DEVELOPMENT HEARING OFFICER
SUPPLEMENTAL SUBMITTAL

PROJECT NO. PR-2022-006674
Application No. SD-2023-00197

December 12, 2023

Re: Preliminary / Final Plat Review for Proposed Lot 16-A and 17-A, Land of Raymond Ortiz

**Plat for  
Lots 16-A and 17-A,  
Land of Raymond Ortiz  
Being Comprised of  
Lots 16 and 17,  
Land of Raymond Ortiz  
City of Albuquerque  
Bernalillo County, New Mexico  
January 2024**

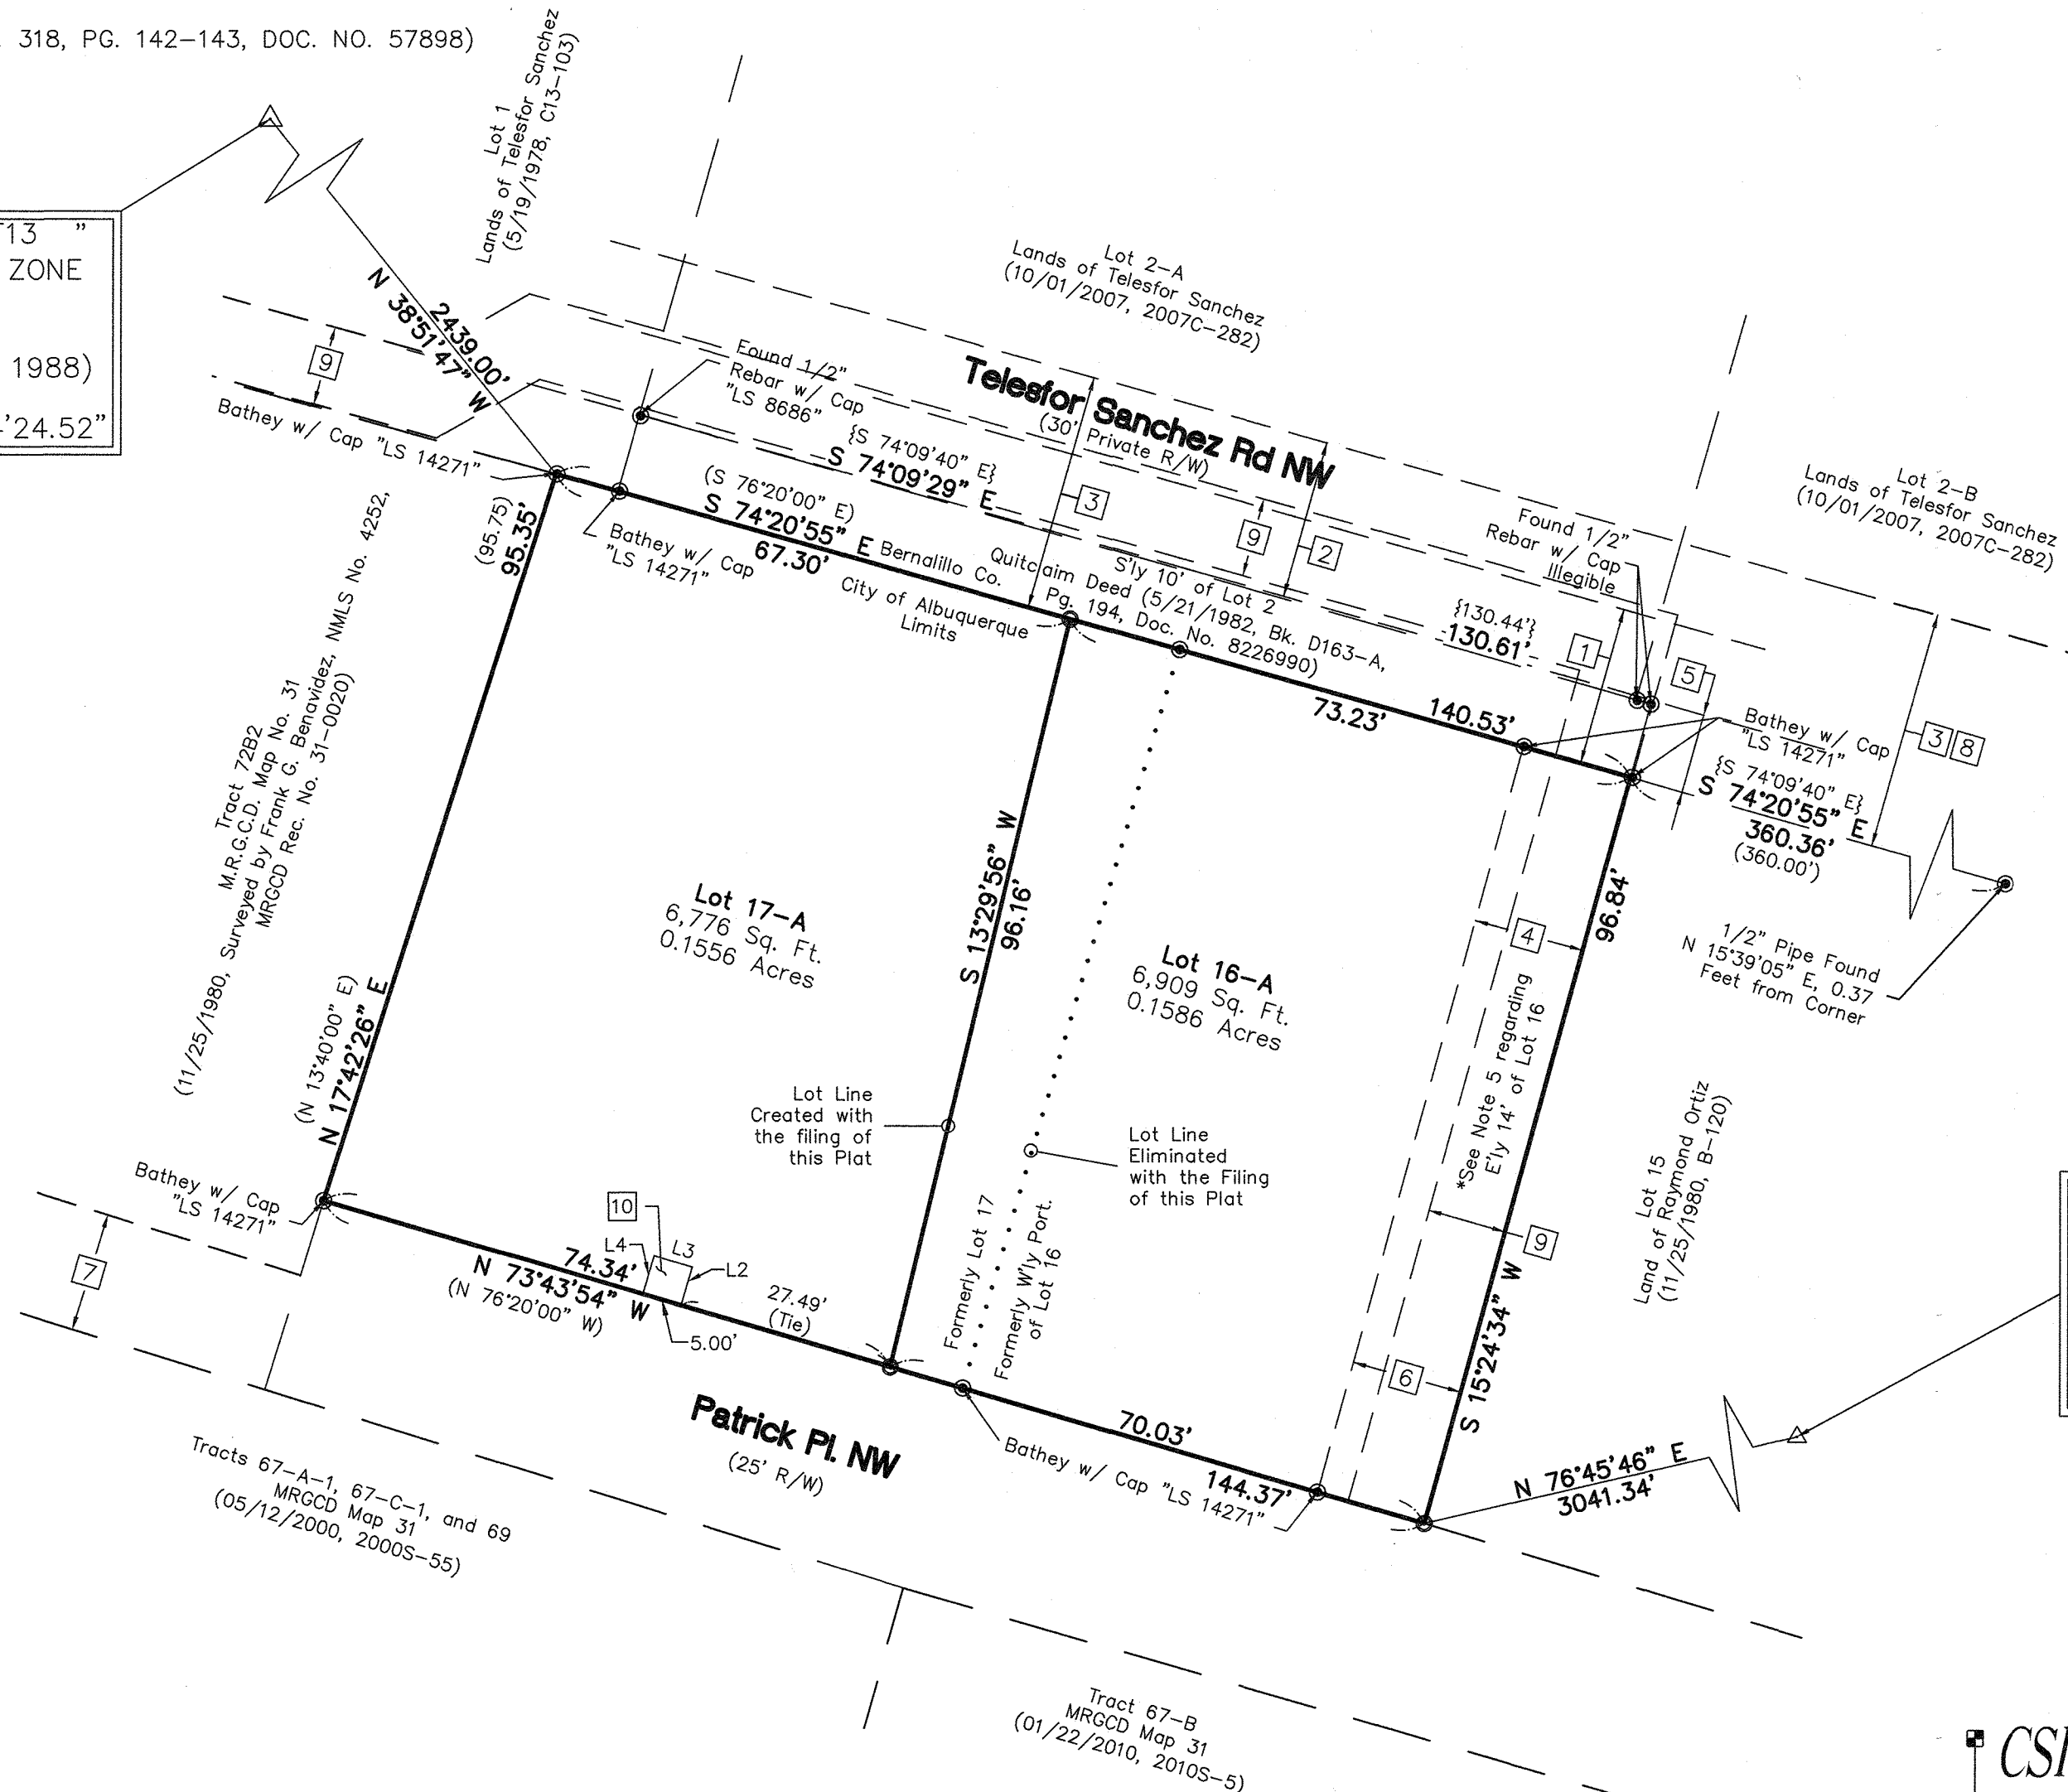
2. Because this is physically a dead-end road, provide a turn-around easement. (In this case, one can be provided within one of the driveways.)

♣ On Sheet 3 of the Plat, ZHE Variance notes are included from the required 10-foot side yard setback, 75-foot minimum lot width, and lot size requirements. Proof of approval of the ZHE Variances and submittal of the Notices of Decision for the approvals must be submitted prior to the approval of the Plat by the DHO.

Easement 6, a private roadway and access easement is present to serve for this purpose (turn around available given dead-end of roadway / unused road easement [7]).

Noted, see notice of decision documents provided in the application bundle.
